**M54 to M6 Link Road
TR010054**

**8.8 LIU(D) Statement of Common
Ground with Nigel Simkin & Paul
Simkin**

**M54 to M6 Link Road
Development Consent Order 202[]**

**8.8 LIU(D) Statement of Common Ground with
Nigel Simkin & Paul Simkin**

Drawing Title: **FIGURE 2.2 ENVIRONMENTAL MASTERPLAN KEY PLAN (REVISION 3)**

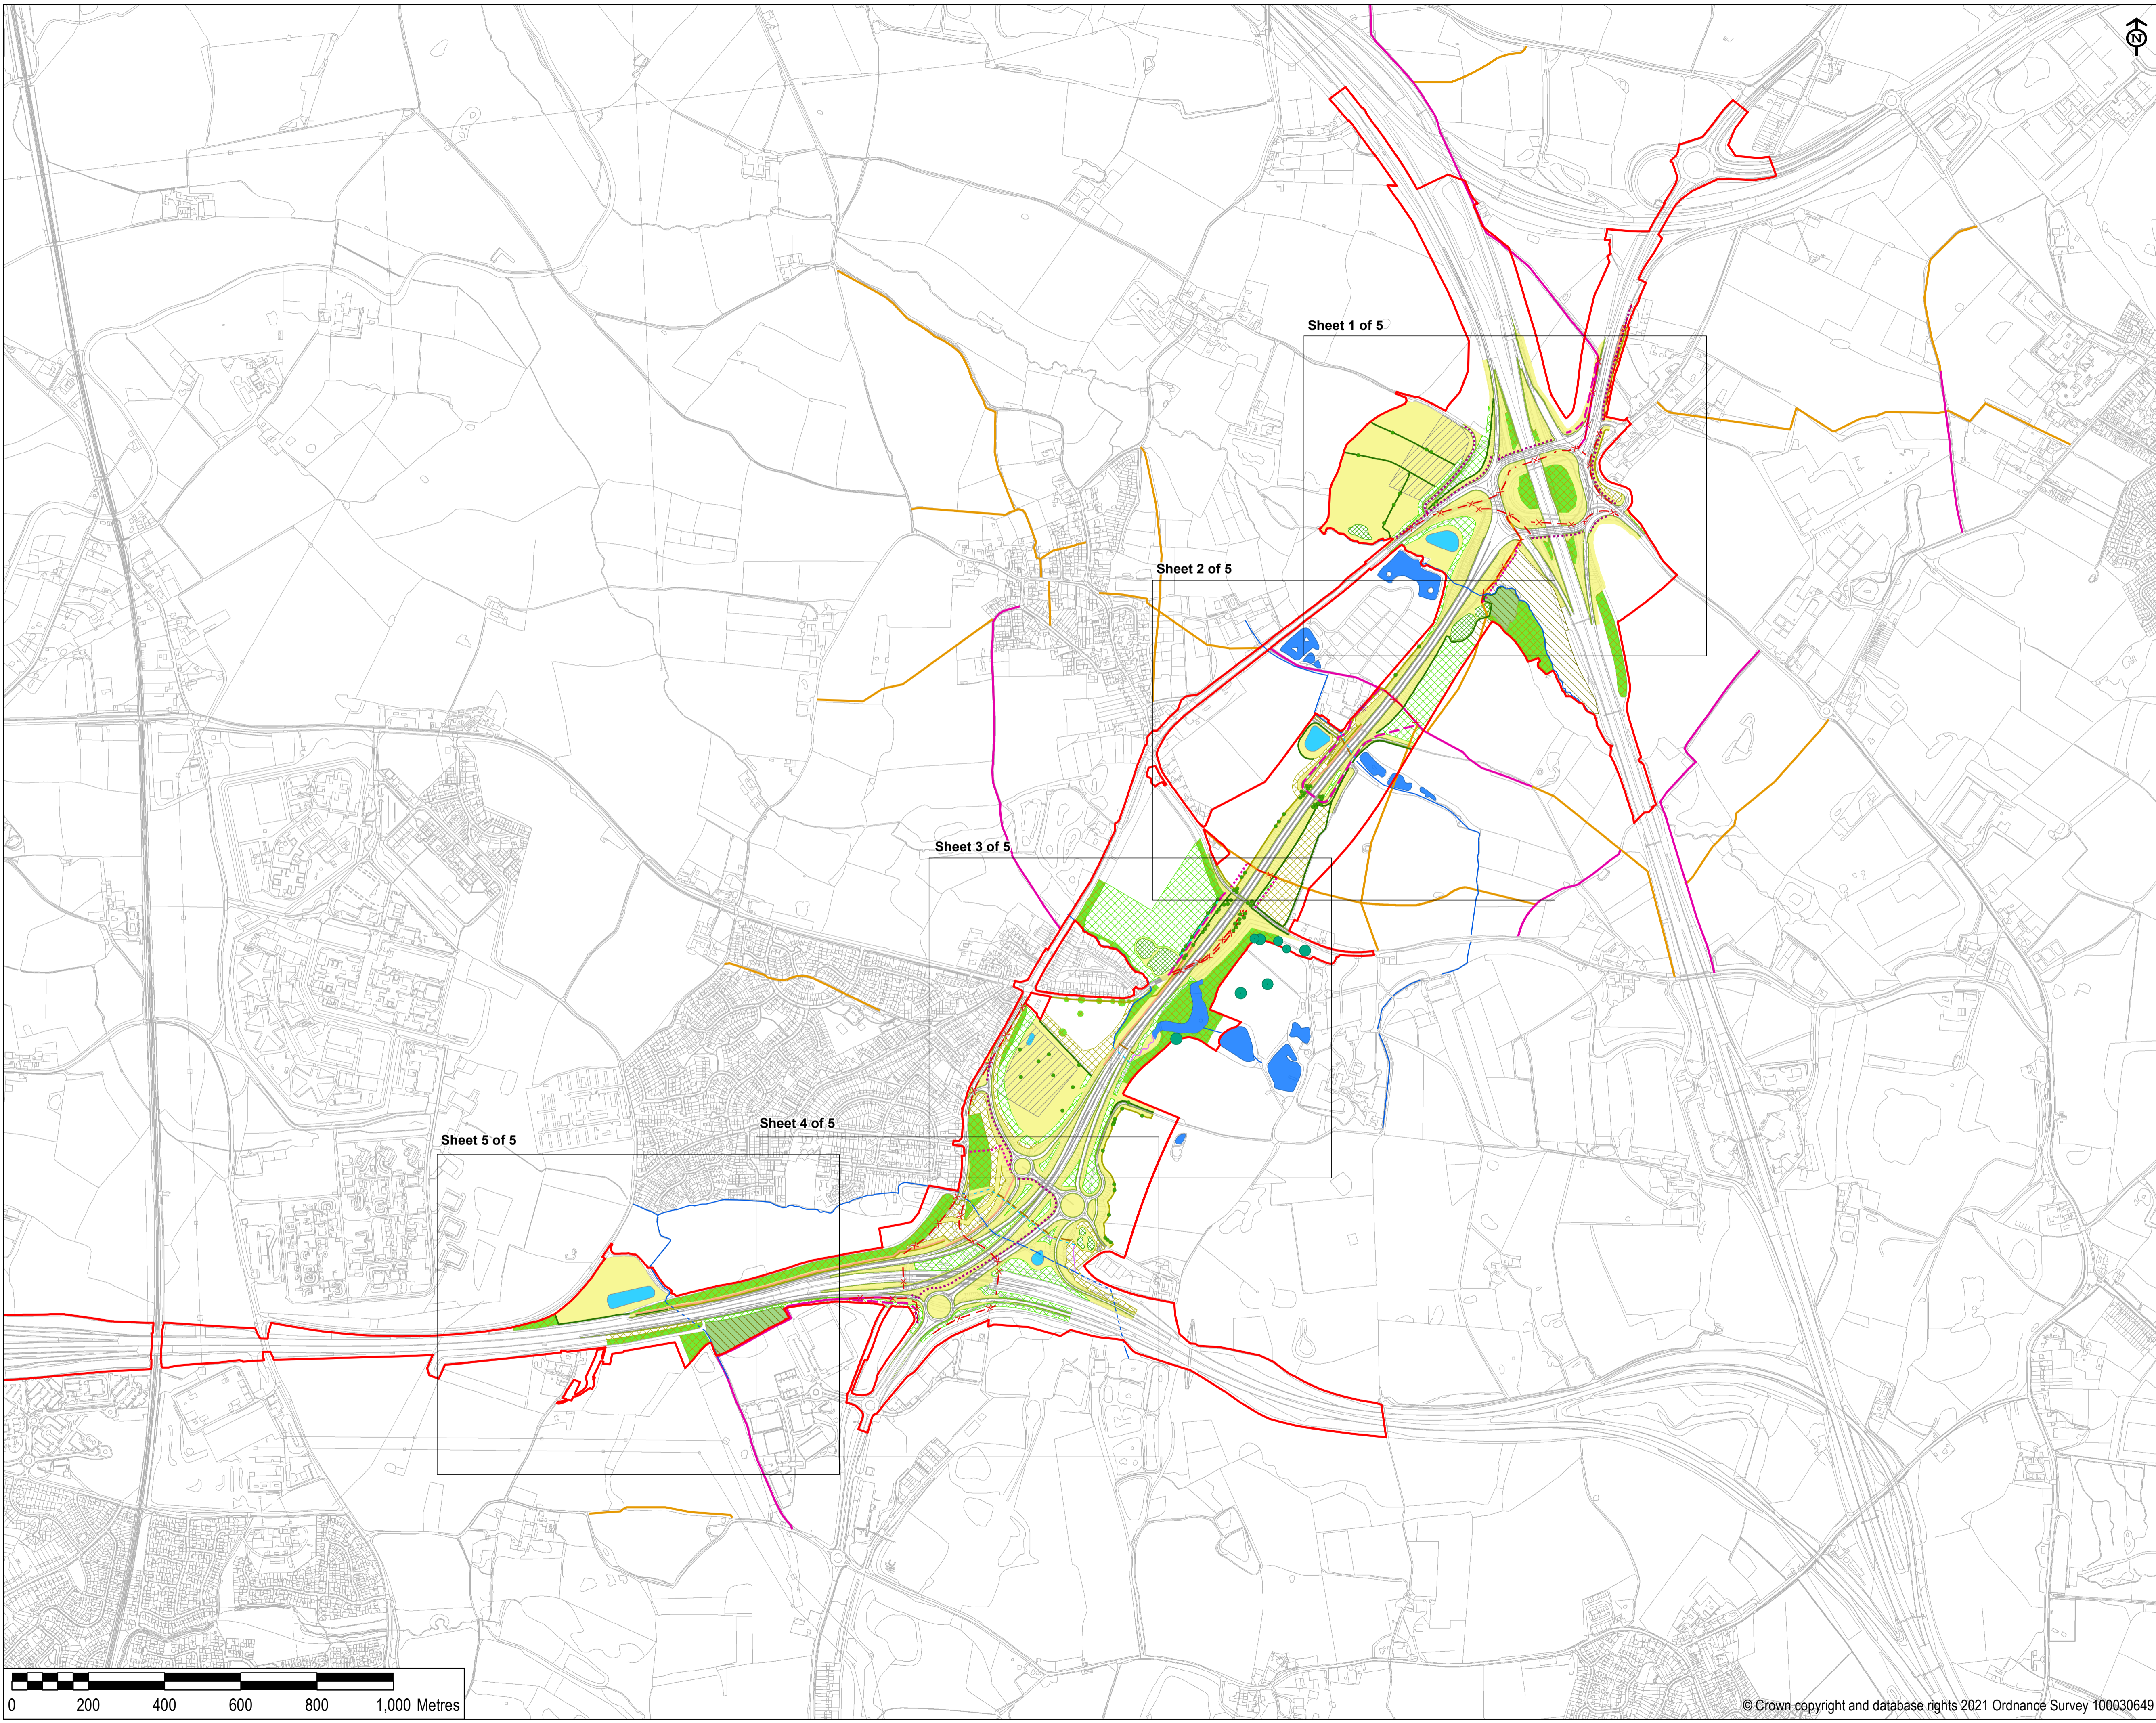
Subject	Document	Landowner Comment	Highways England Response	Status	Agreement likely ¹
	the changes to the DCO	welcomed however there appears to have been no reduction in the level of environmental mitigation planned on our client's landholding. In fact, the Environmental Masterplan indicates that there are to be additional hedgerows planted to the east of the link road.	<p>landowner's plot will reduce the mitigation on that plot.</p> <p>A mosaic of habitats has been included across the length of the Scheme but necessarily focused in selected locations to provide connectivity for protected species and designated sites. A reduction in habitat loss as a result of design changes and new survey data has enabled a reduction in the amount of land taken as mitigation from some landowners but not for all.</p> <p>Additional hedgerows have been proposed to provide boundary features for landscape integration and this also provides ecological enhancements on land that will be acquired for other purposes. Those areas are not being acquired for the sole purpose of hedgerow planting, but have been identified to mitigate visual and biodiversity impacts and around the Scheme.</p>

Subject	Document	Landowner Comment	Highways England Response	Status	Agreement likely ¹
		<p>With regards the suggestion there will be a small reduction in the area of ‘ancient woodland’ here, we have reviewed the previous Environmental Masterplan together with the revised Environmental Masterplan and can find no difference or change to the area of ancient woodland identified.</p> <p>Furthermore, we have previously raised that the area shown above has only recently been designated “ancient woodland” through the course of consultation meetings between Highways England and Natural England in relation to the scheme.</p> <p>Our clients dispute that the land is ancient woodland and has noted that the ancient woodland area identified has very young trees (i.e. not over 200 years old). They feel it is</p>	<p>There has been no reduction in the area of ancient woodland identified. Design change 3 (submitted on 9 October 2020) reduces the width of the embankment adjacent to the area of ancient woodland located within Brookfield Farm SBI, which reduces the loss of ancient woodland. The assessment reported in Chapter 8: Biodiversity of the ES [APP-047/6.1] identified 0.0015 ha of ancient woodland which would be lost during the construction of the Scheme, with a further 0.042 ha of ancient woodland located within 15 m of the construction works assumed to be lost due to the potential for root damage at this distance.</p> <p>The design change limits the loss of ancient woodland to 0.029 ha within 15 m of the construction works only. This level of detail is not shown on the draft Environmental Masterplan but is assessed within the Environmental Statement (updated chapter 8 submitted to the ExA on 09/10/20 [AS-083/6.1]). In addition, there is a loss</p>	Under discussion	Medium

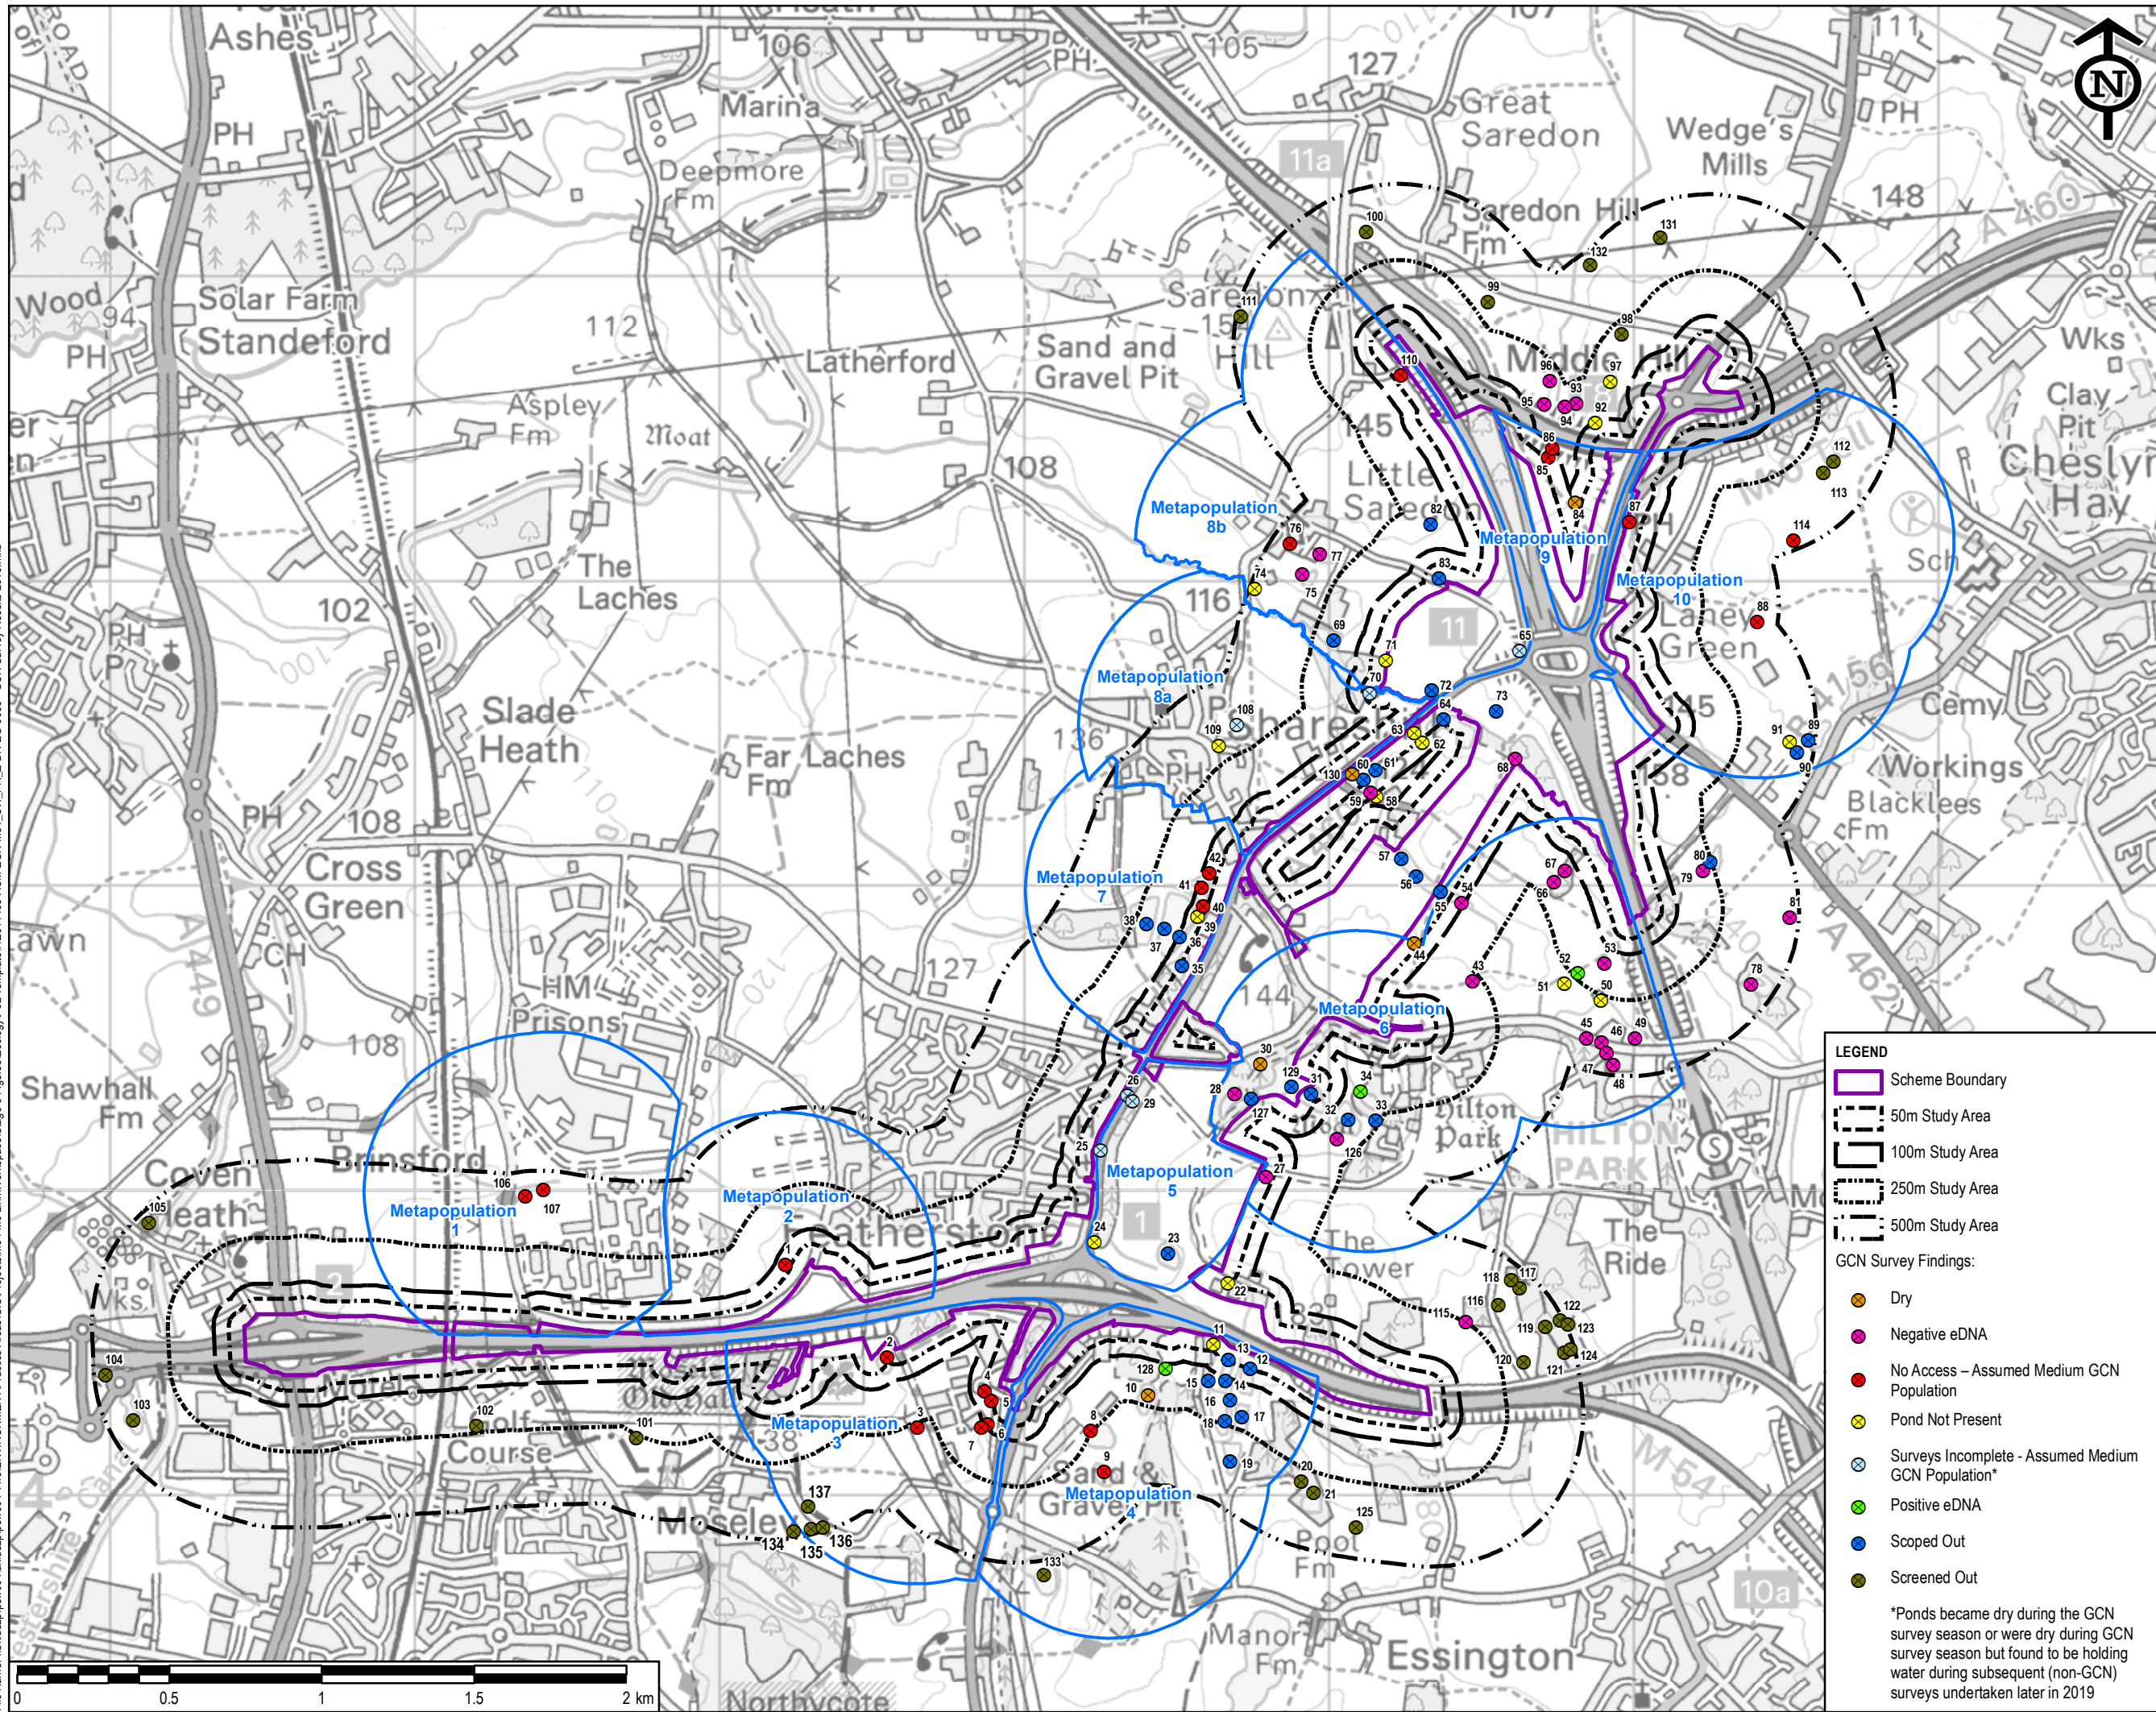
<p>Landowners' response to review of previous above supplementary consultation within draft 2 of SoCG response</p>	<p>we note that Highway England approach to measuring the population of GCN's across the area has been extremely cautious and appears to significantly overestimate both the number and size of GCN breeding populations within 500m of the road, which we</p>	<p>Natural England Great Crested Newt Mitigation Guidelines (2001) Section 5.2 and 5.4 references a distance of 500m as being the trigger for undertaking surveys for GCN. Section 8 of the same guidelines refers to an area of terrestrial habitat up to 500 m</p>	<p>Under discussion</p>	<p>Medium</p>

<p>understand is double the required distance.</p>	<p>around a pond being considered as potential newt habitat.</p> <p>Natural England’s Method Statement Template for licensing (April 2020) refers to the need to undertake surveys at distances beyond 250 m when certain criteria are met:</p> <ol style="list-style-type: none"> 1) maps, aerial photos, walk-over surveys or other data indicate that the pond(s) has potential to support a large great crested newt population 2) the footprint contains particularly favourable habitat, especially if it constitutes the majority available locally 3) the development would have a substantial negative effect on that habitat 4) there is an absence of dispersal barriers. <p>Criteria 1 is difficult to dismiss, as large sized populations of newts can be found in what could be classified as a poor quality waterbody. The footprint of the Scheme contains particularly favourable newt habitat (deciduous woodland and hedgerows). Large amounts of this</p>
